City of Portland, Maine - Building or Use Permit Application
 389 Congress Street, 04101 Tel: (207) 874-8703, Fax: (207) 874-8716

Permit No: 03-0932	Issue Date: SEP 23 2003	CBL: 406 F032001
-----------------------	-----------------------------------	---------------------

Location of Construction: 158-162 Marlborough Rd (Lot #2)	Owner Name: Jocelyn Deraspe	Owner Address: 910-B Washington CITY OF PORTLAND	Phone: 653-6760
Business Name:	Contractor Name: David Chase	Contractor Address: Portland	Phone: 2077763031
Lessee/Buyer's Name:	Phone:	Permit Type: Single Family	Zone: R-3

Proposed Project Description: Single family dwelling: construct 1,718 s.f dwelling + 14' x 26' garage	Signature: _____ Signature: JMB 9/23/03 PEDESTRIAN ACTIVITIES DISTRICT (P.A.D.) Action: <input type="checkbox"/> Approved <input type="checkbox"/> Approved w/Conditions <input type="checkbox"/> Denied Signature: _____ Date: _____
--	--

FOUNDATION PLAN

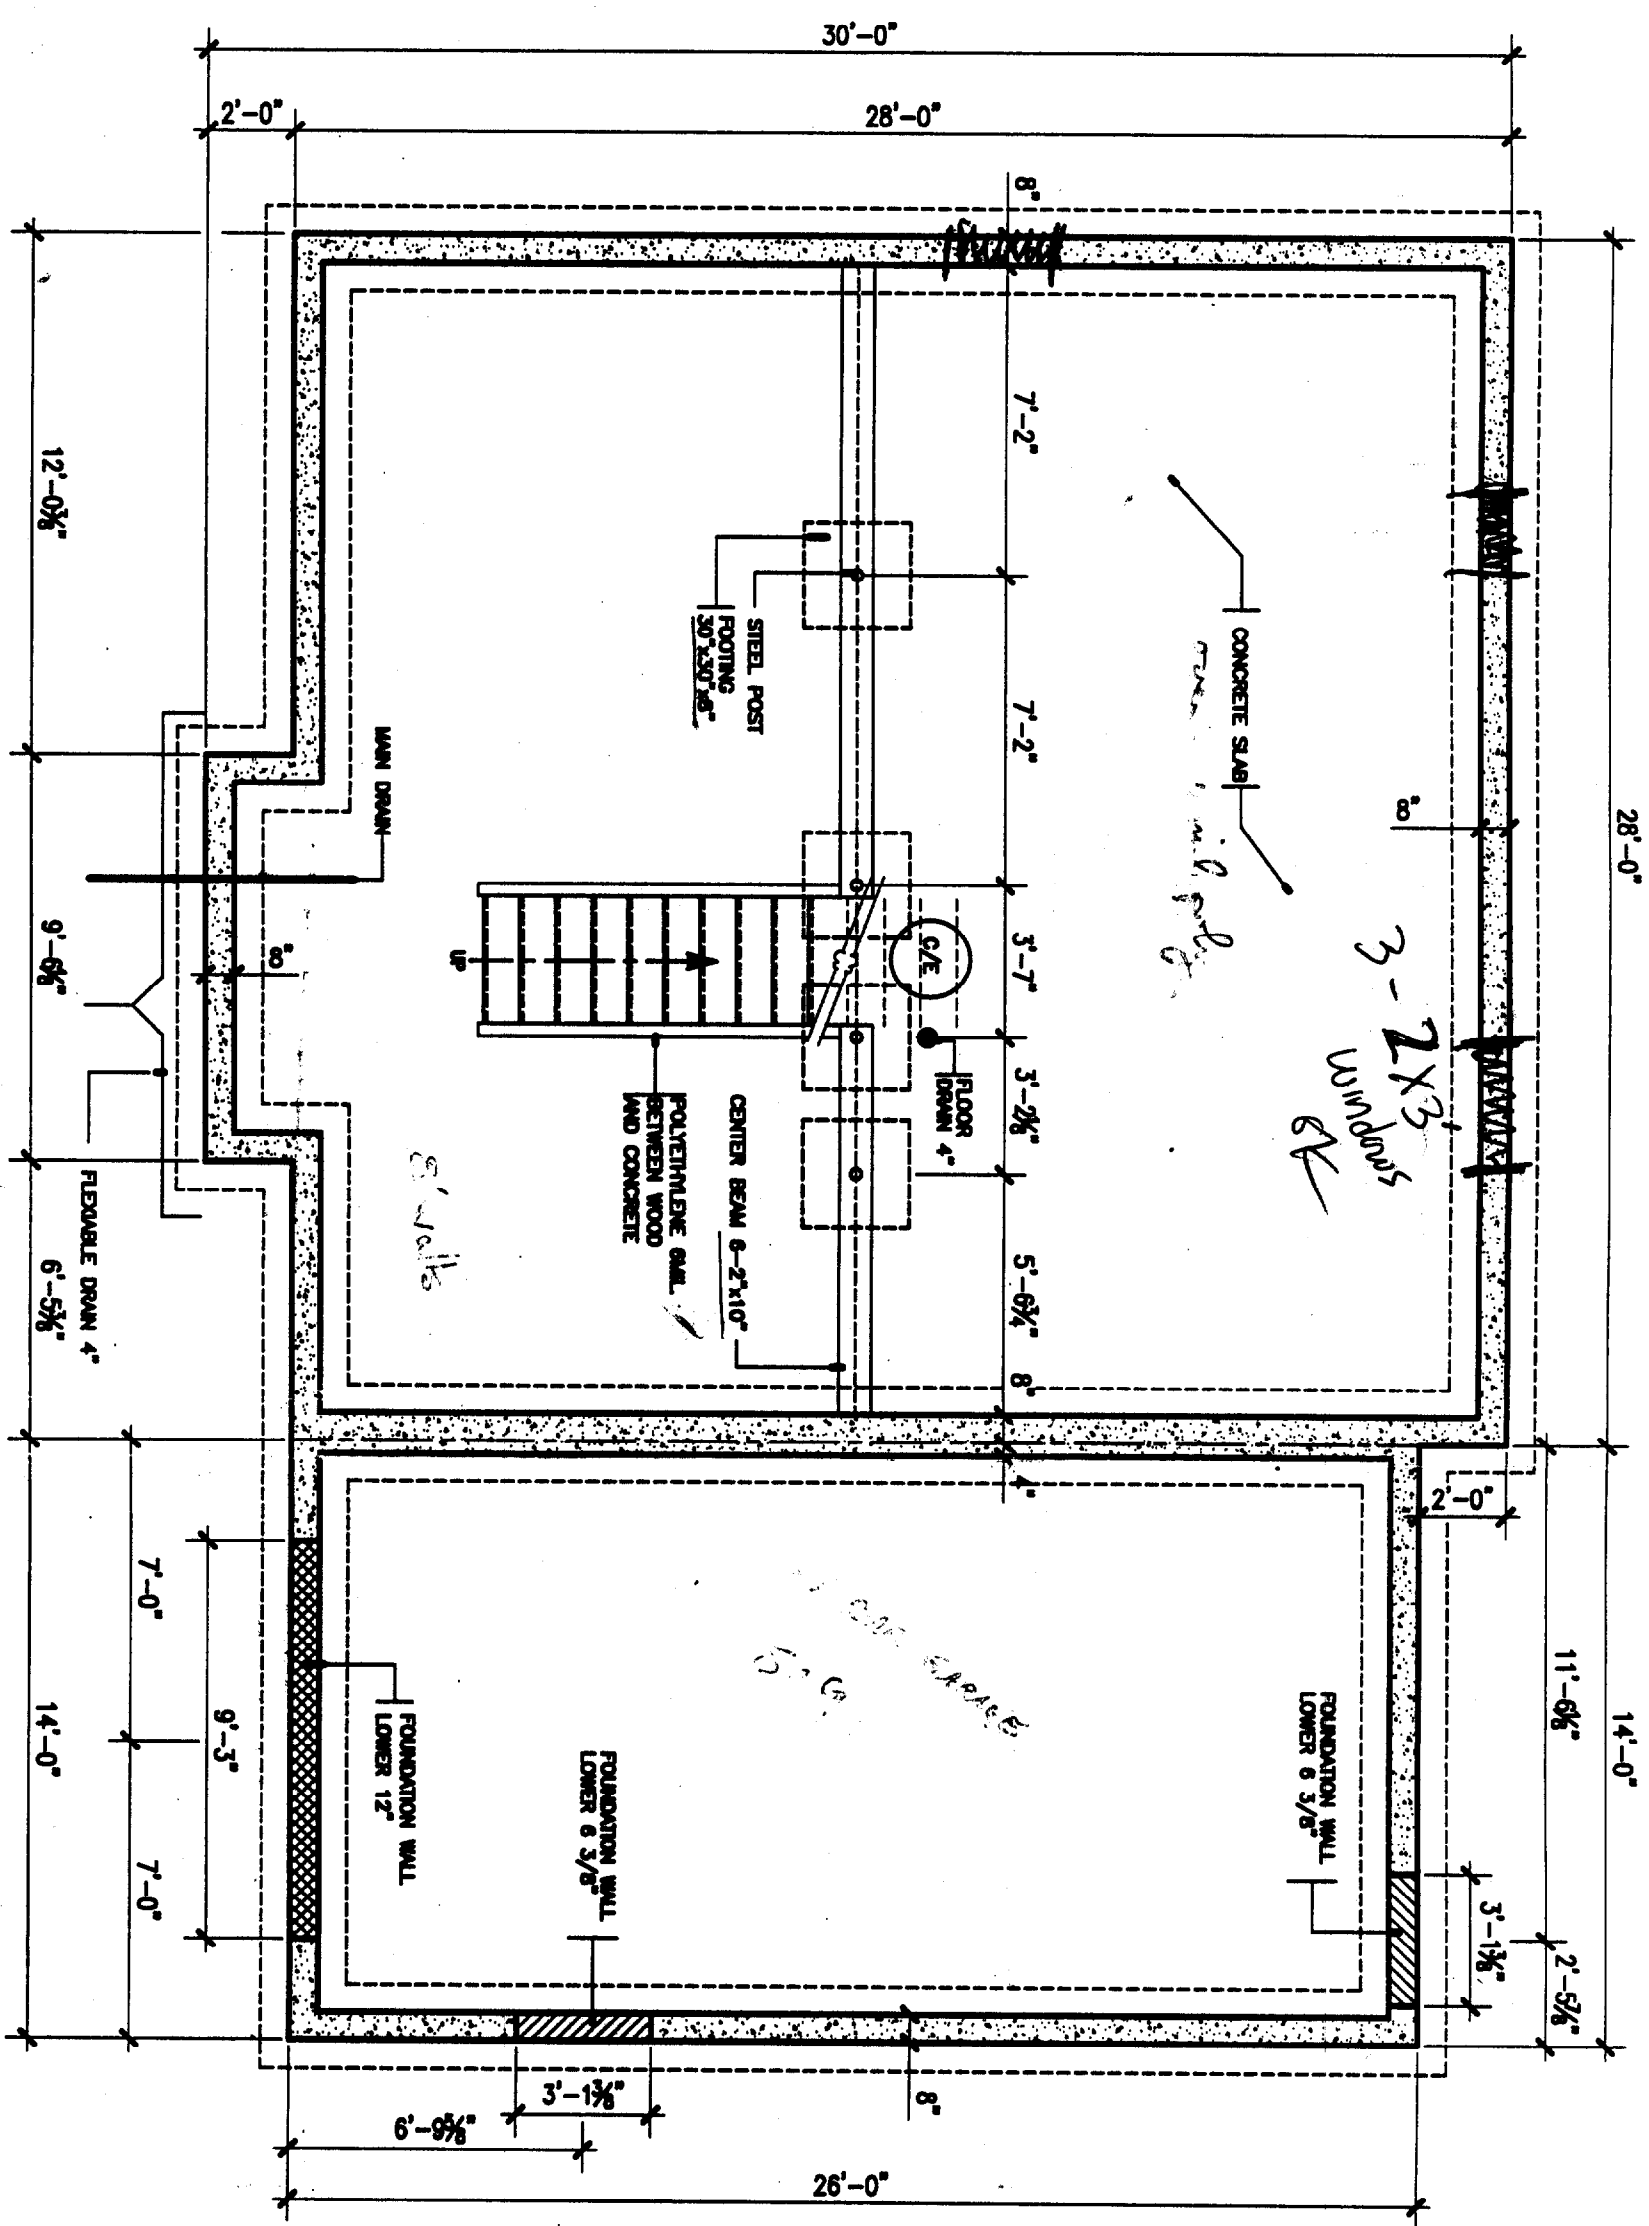
- 1) Separate permits shall be required for future decks, sheds, pools, and/or garages. No side or rear decks are shown on the plans. Therefore none are approved. No daylight basement is shown and therefore has not been approved.
- 2) This permit is being approved on the basis of plans revised plans submitted 9/8/03 and revisions approved by owner on 9/10/03. Any deviations shall require a separate approval before starting that work.
